Appeal Decision

by Jonathan Manning BSc (Hons) MA MRTPI

Appeal Ref: APP/R5510/D/14/2222001

42a Wood Lane, Ruislip, Middlesex, HA4 6EX

South west elevation 1:50
PROPOSED

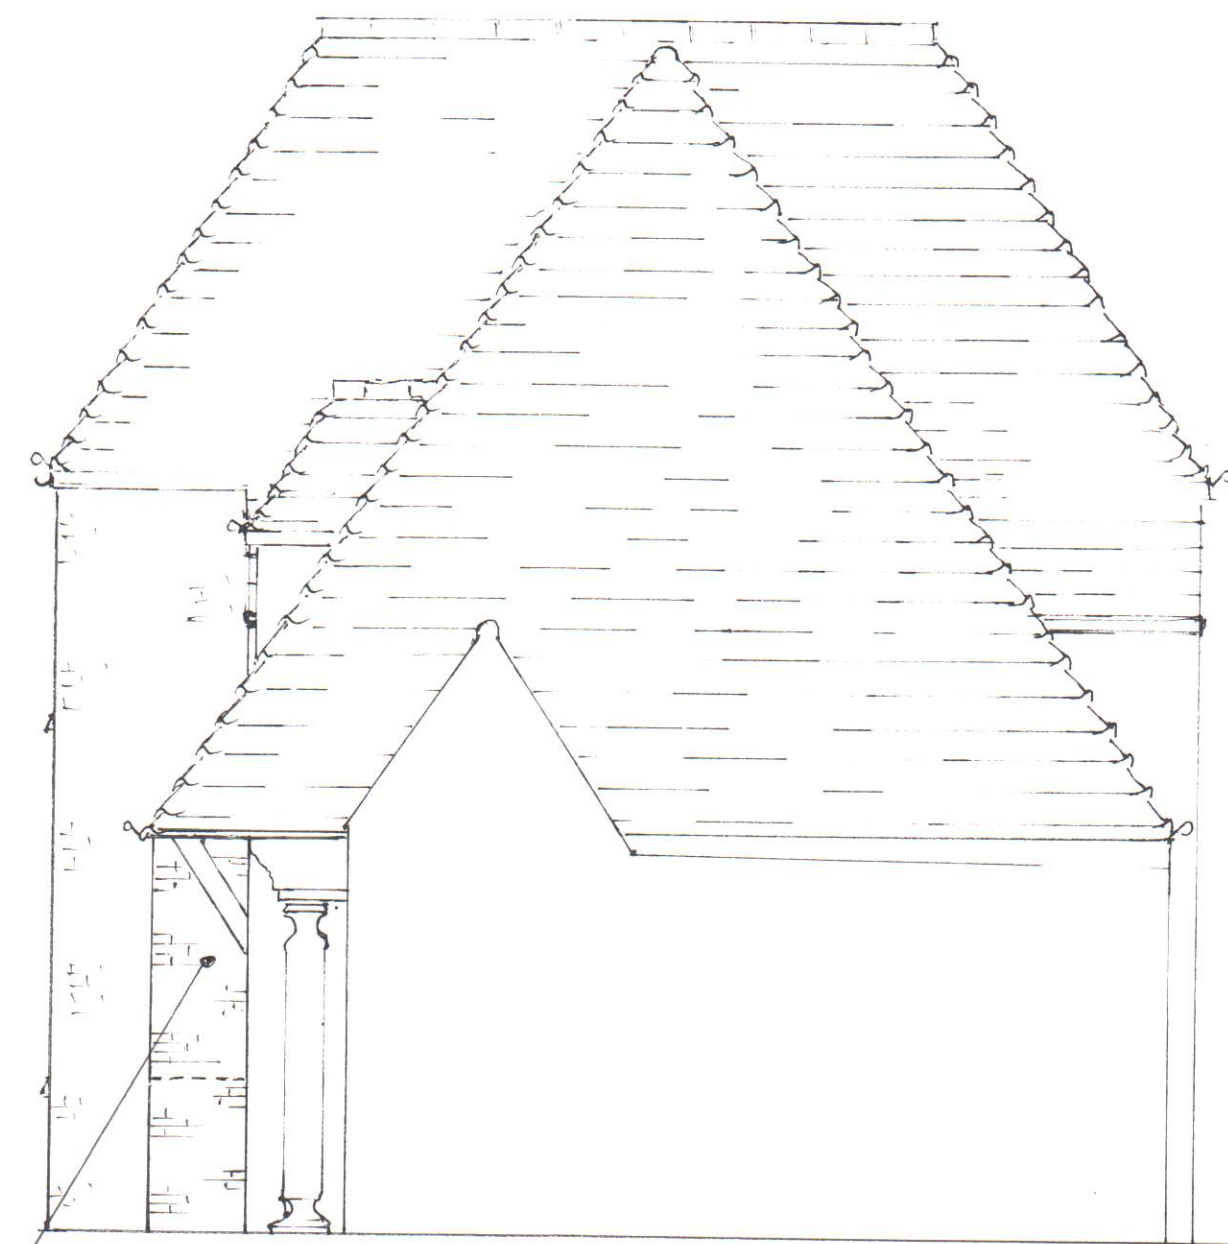
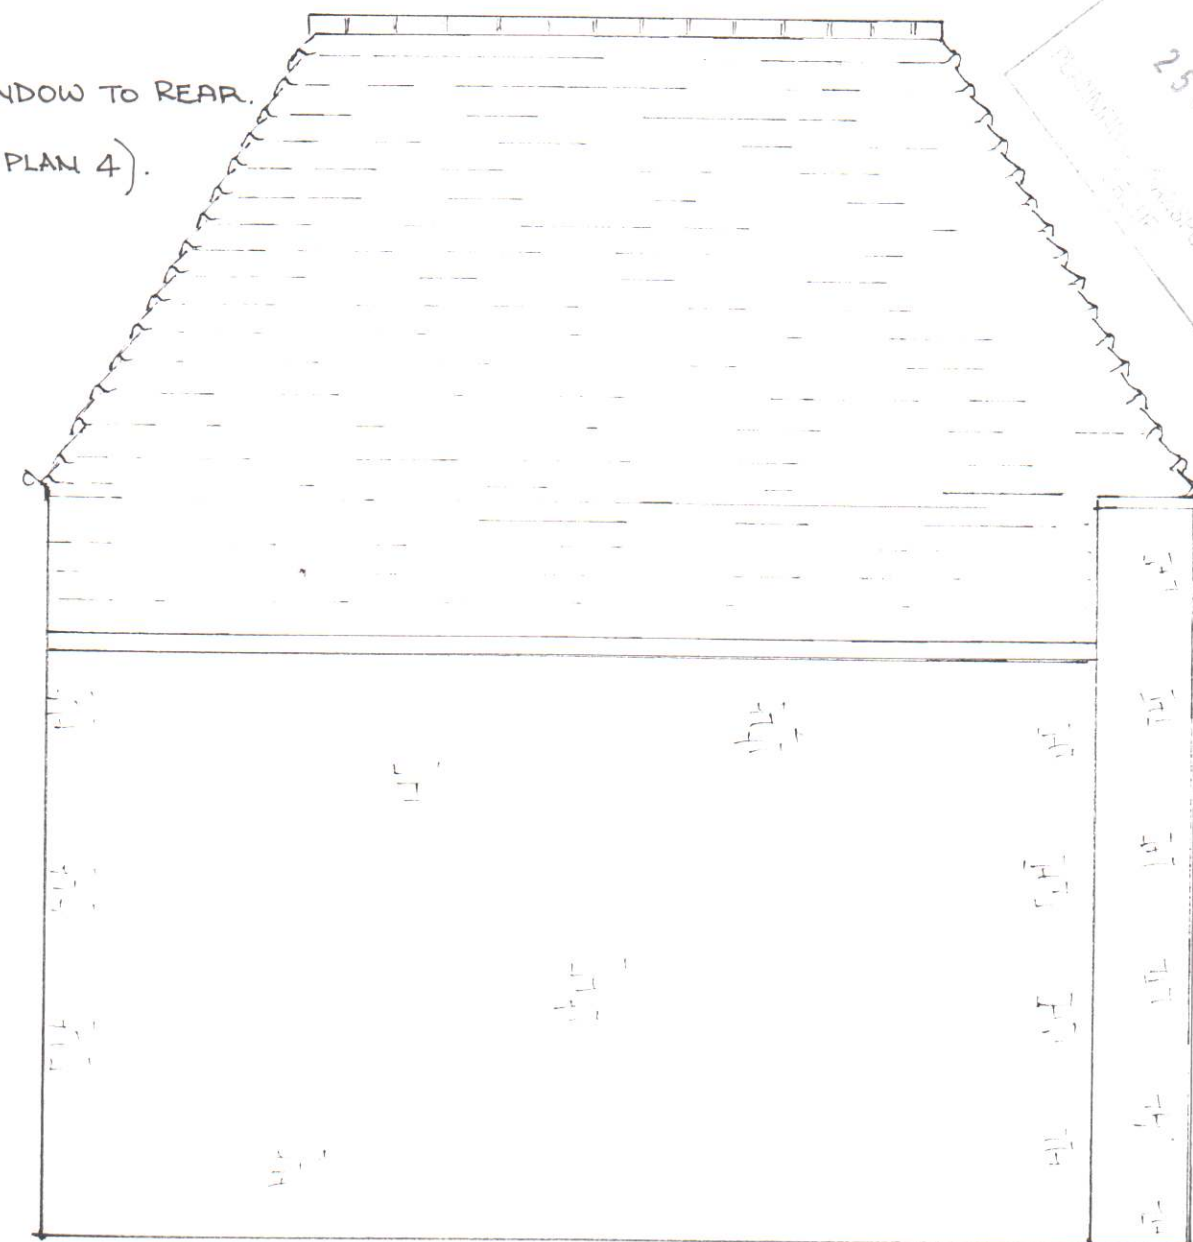
4. The proposal would result in the construction of a two storey side extension adjacent to the existing entrance connection and above/incorporating the current single storey extension. The proposed extension would have a depth of approximately 7.65 metres and a width of approximately 4.75 metres. The maximum ridge height would be approximately 8 metres to match the existing dwelling. The accommodation would include sitting room, kitchen, two bedrooms, en-suite and a bathroom.

6. It is evident that the proposal being of a similar height and of a comparable width and depth to the host property, which would not be set back from the main front building line, would not comply with this guidance. The proposed extension would result in an overly dominant addition to the host property that would not be subordinate in appearance, causing harm to the character and appearance of the host property.

7. I observed that the proposal due to its significant size and its replicated gable feature would compete with the host dwelling and undermine its special architectural and visual qualities that positively contributes to the street scene and the wider Conservation Area. As a result of this, the proposal would appear as an inappropriate feature within the street scene that would not harmonise with its immediate context and would be detrimental to the character and appearance of the Ruislip Village Conservation Area. I consider that the harm to the significance of the Conservation Area as a whole to be less than substantial, therefore the public benefits of the scheme need to be weighed against the identified harm. The proposed development would provide increased living accommodation and I note the aim of the development is to provide living space for the appellant's family. However, in the absence of any more immediate public benefits, I do not consider that this outweighs the identified harm.
